Sheringham Shoal and Dudgeon Offshore Wind Farm Extension Projects

The Applicant's comments on Oulton Parish Council's
Deadline 5 Submission

Document Reference: 20,11

TITLE  
B1149 OULTON  
DRAFT  
ACC25b ACCESS DESIGN  
(SHEET 2 OF 2)

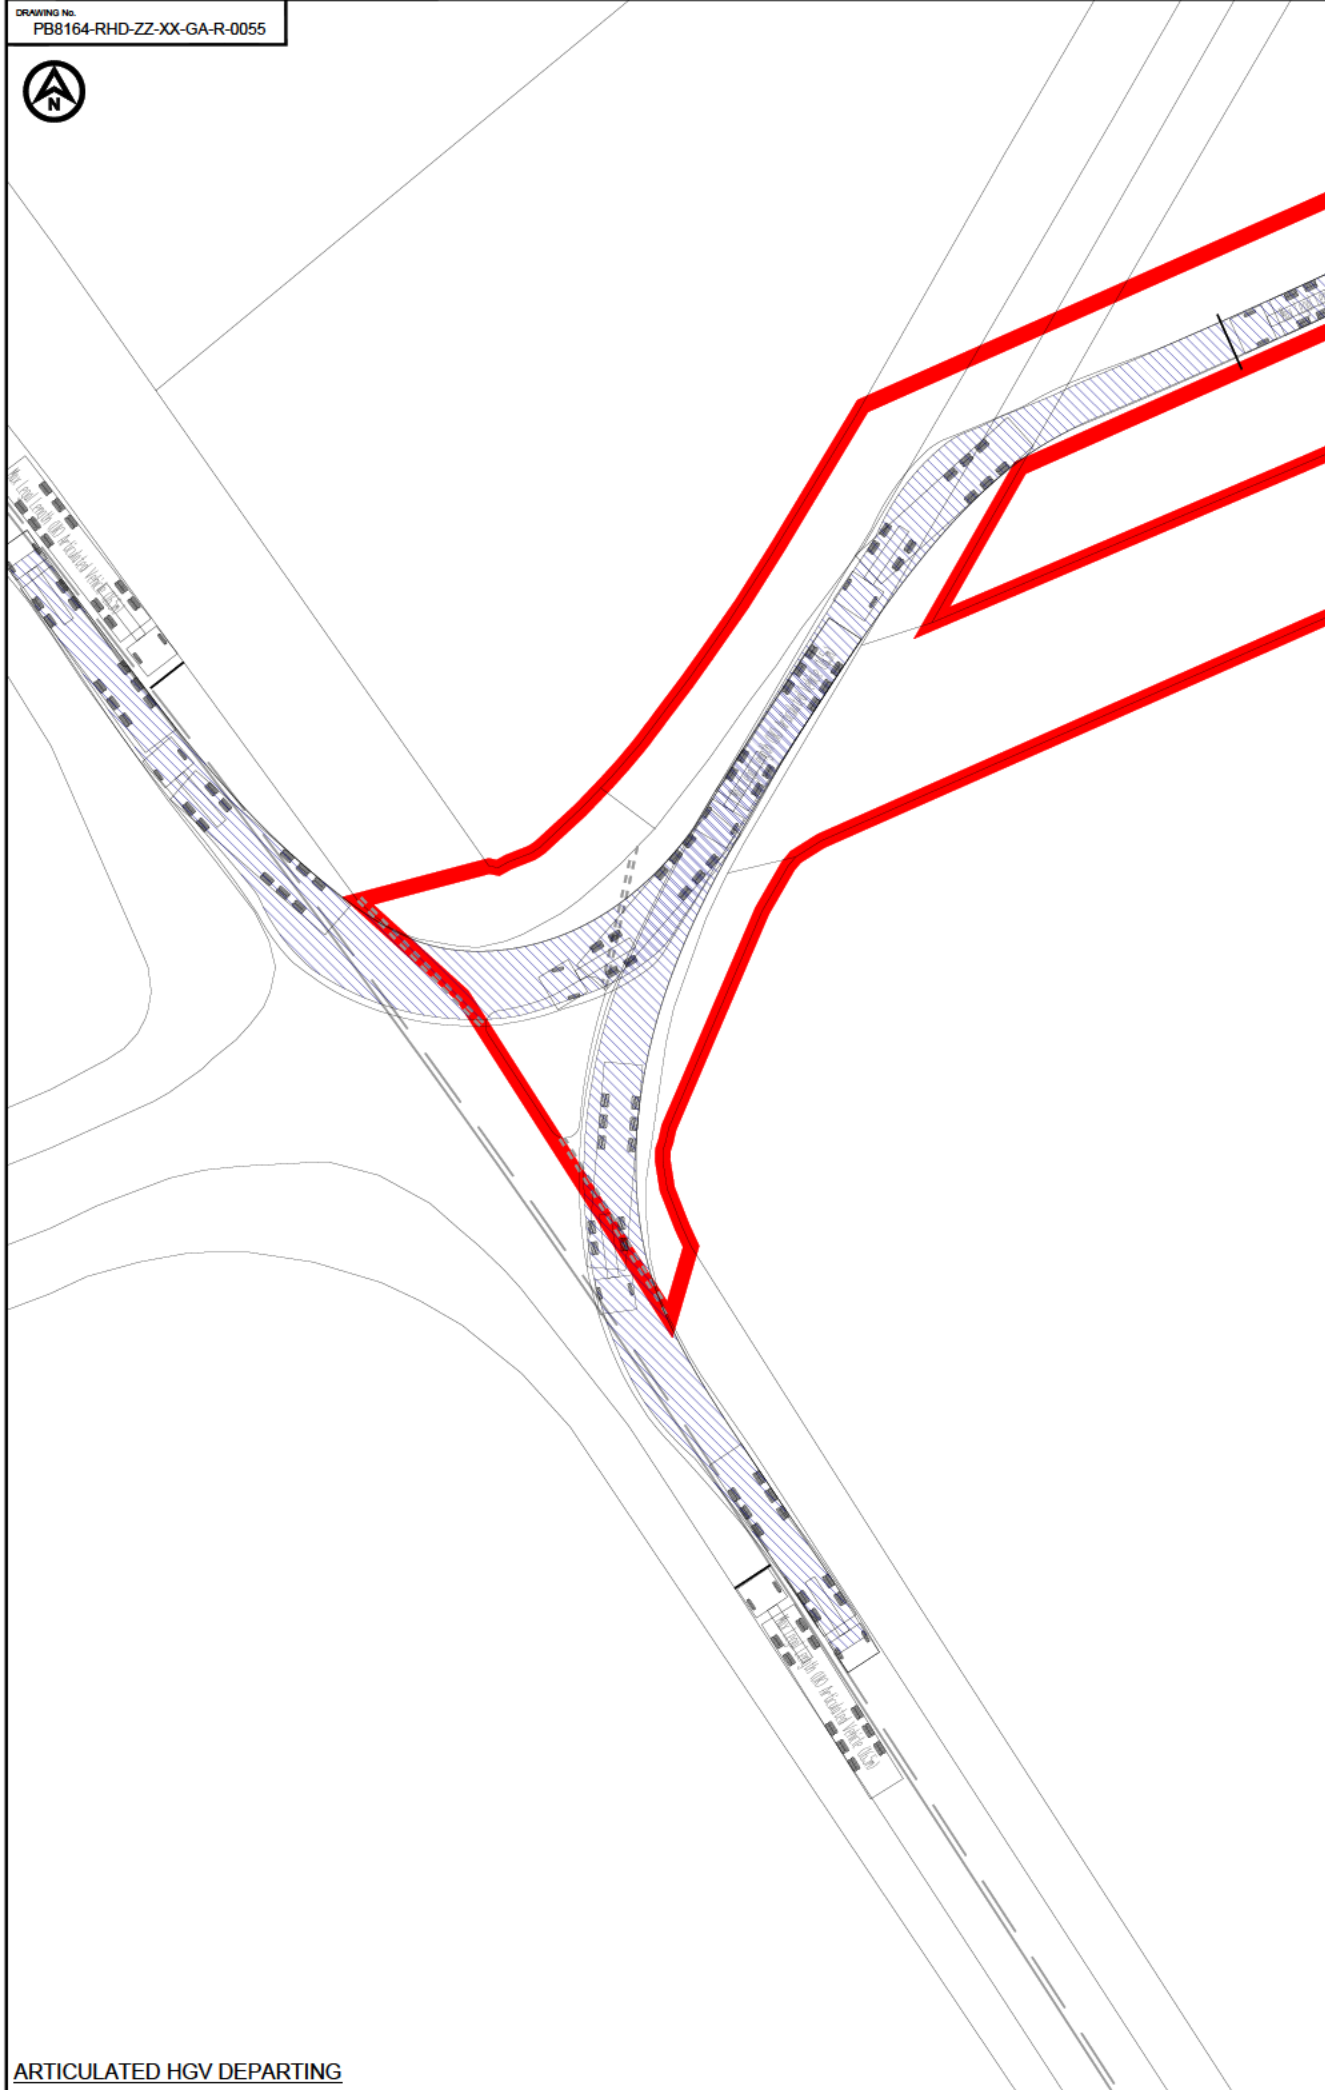
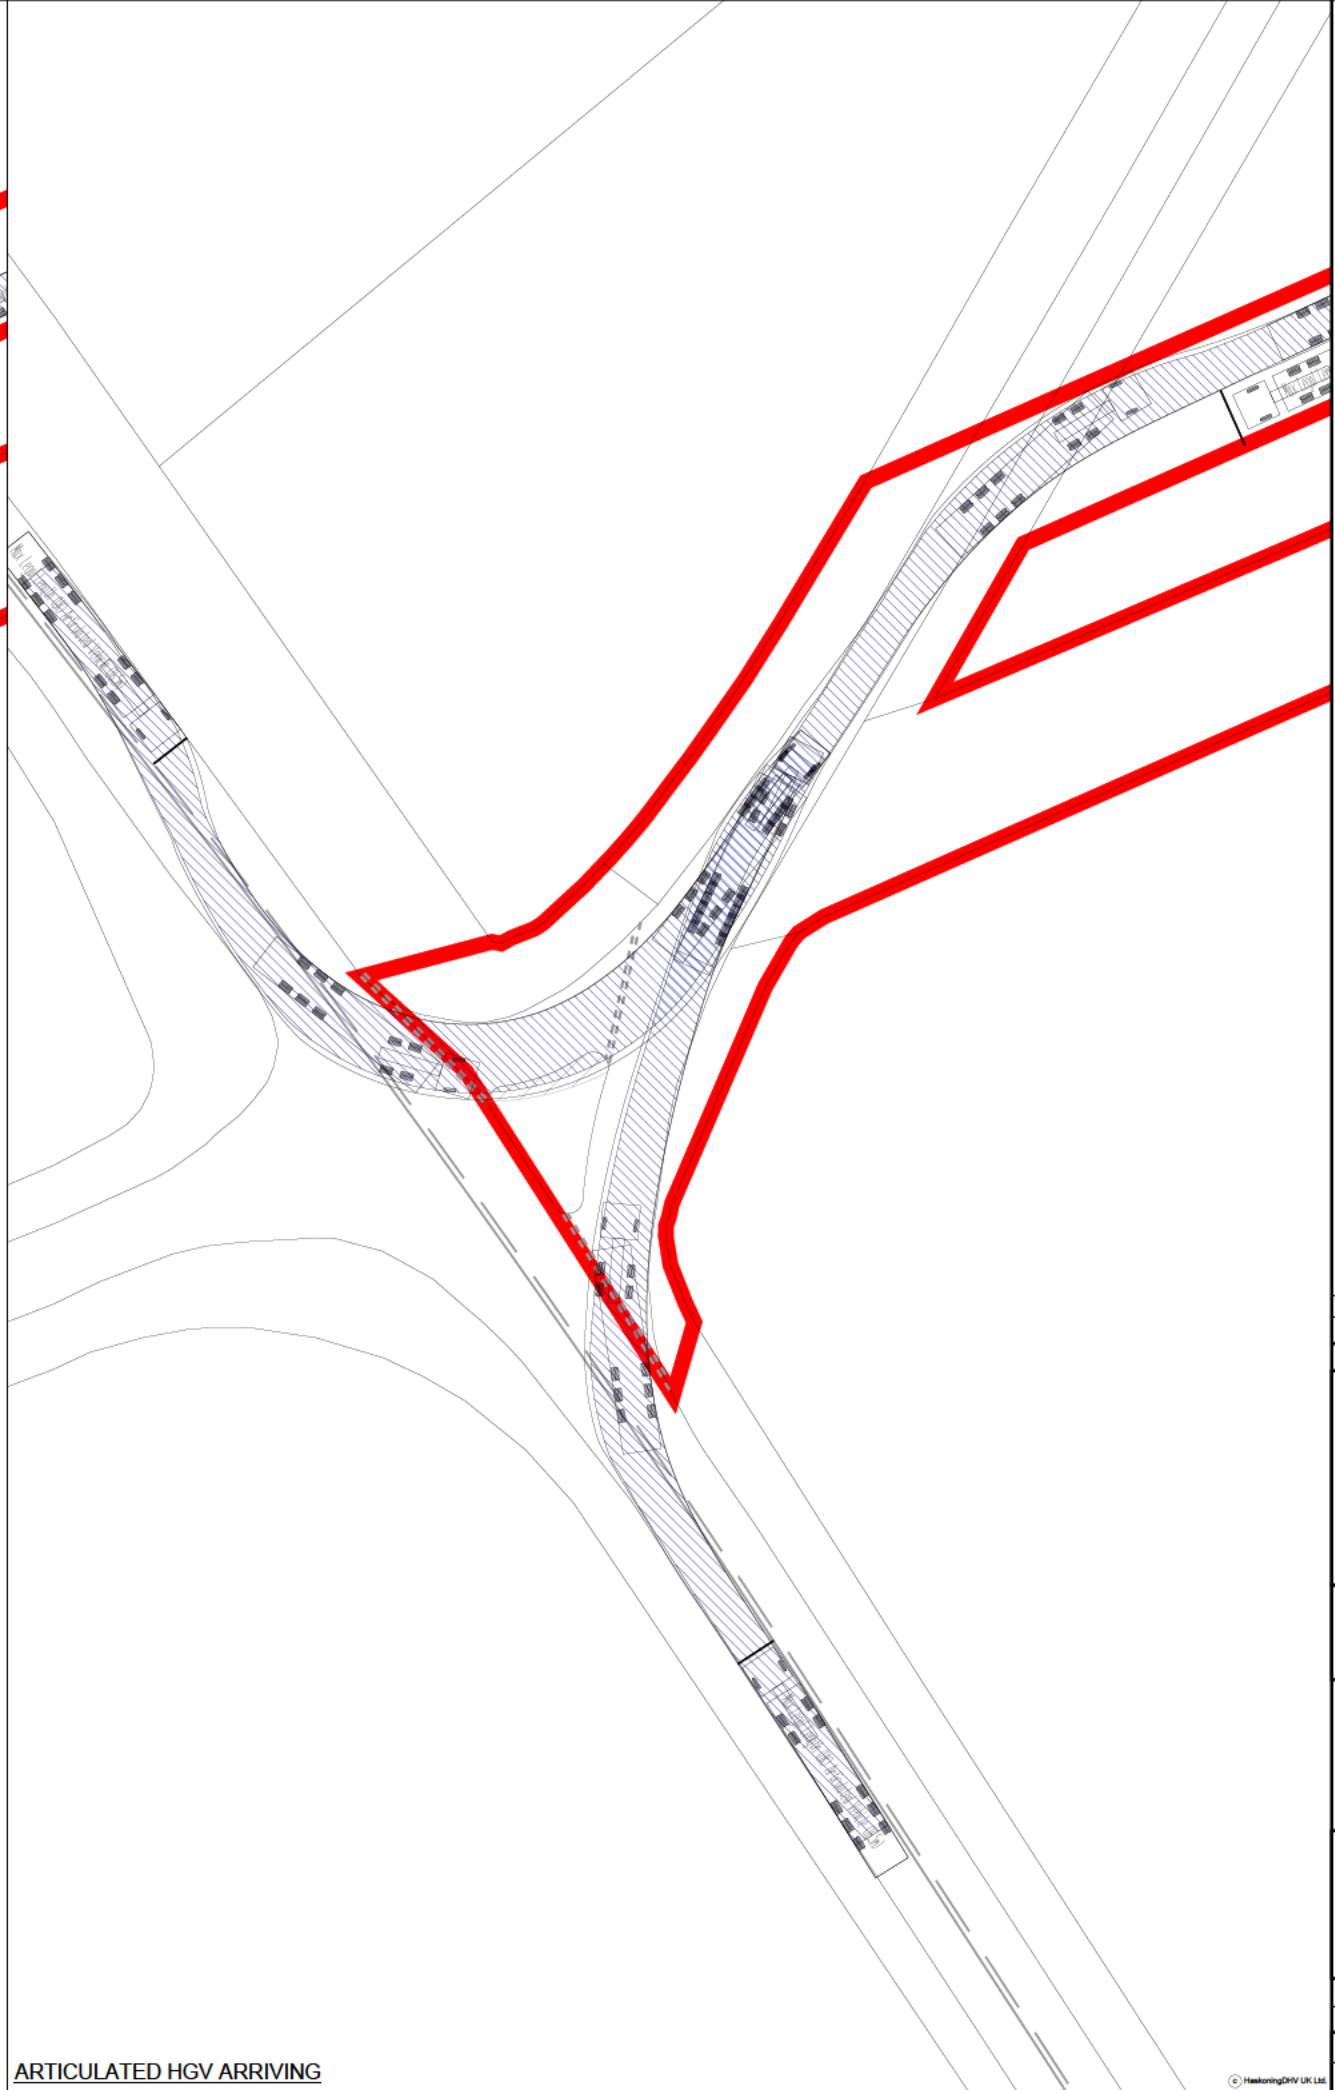
3	<p>Re: Q.2.23.5.5.</p> <p>The Applicant has answered the question which relates to ACC25B to Bluestone Cottage and access to the property.</p> <p>OPC have queries which relate to the proposed use of traffic signals for</p>	<p>It is anticipated that ACC25 will be utilised for a period of 6 months by construction traffic and ACC25b will be utilised for a period of 2 months by construction traffic. There will be a short duration (up to two months) where the accesses will be utilised at the same time.</p> <p>The applicant has agreed a traffic management strategy for ACC25 and ACC25b with Norfolk County Council to minimise disruption for highway</p>

ID	Stakeholder Comment	Applicant Response
	<p>ACC25 temporary compound <u>and</u> ACC25B cable route and HDD works.</p> <p>OPC note from the revised OCTMP (APP-301 revision C) submitted at Deadline 3, that there is mention of temporary traffic lights at ACC25B, along with plans (<i>pages 50-52</i>) for the traffic signalling and swept path information at this location.</p> <p>However, there are also plans for traffic lights at ACC25 (<i>pages 53-55</i>) which gives access to the temporary compound from B1149. The Applicant has not indicated whether ACC25 will be in operation at the same time as ACC25B. OPC would seek clarification on how the two sets of traffic lights will interact and how long the temporary compound will be needed for, and whether ACC25 traffic lights have the same restrictions as ACC25B?</p> <p>OPC can find no reference to time frames for temporary compounds. It was OPC's understanding that both accesses would <u>not</u> be in use at the same time.</p>	<p>users. It entails simultaneous operation of traffic signals for a short duration, restricted operating hours and manual control for ACC25b.</p> <p>Full details of the agreed traffic management strategy are contained in the Applicant's Deadline 5 Submission, Outline Construction Traffic Management Plan (Revision D) (Tracked) [REP5-028], Section 4.4 and agreement confirmed in the Draft Statement of Common Ground with Norfolk County Council (Revision D) [REP5-033], Section 2.3, ID 24.</p>

6	<p>OPC are unaware of this having been explained in the OCTMP. The Applicant will therefore need to explain the operational design for ACC25(temporary compound) with ACC25b (cable route/HDD), along with any cumulative impacts of traffic lights near to the junction of the B1149 with The Street and Link 131 (SEP/DEP), Link 68 (Vanguard/Boreas) Link 208 (Hornsea Three Main Construction Compound).</p>	
7	<p>Will traffic held at the traffic lights along the B1149 cause any tailback that might result in a blockage to the junction of the B1149 with The Street (Links 131/68/208 referred to above)?</p>	
8	<p>This could result in backups for traffic entering and exiting the junction or cause backups further along the B1149 at Cawston roundabout or Saxthorpe roundabout, especially in light of the huge increase in HGVs along this section of road, caused by the NSIPs, together with seasonal agricultural vehicles, and tourist traffic.</p>
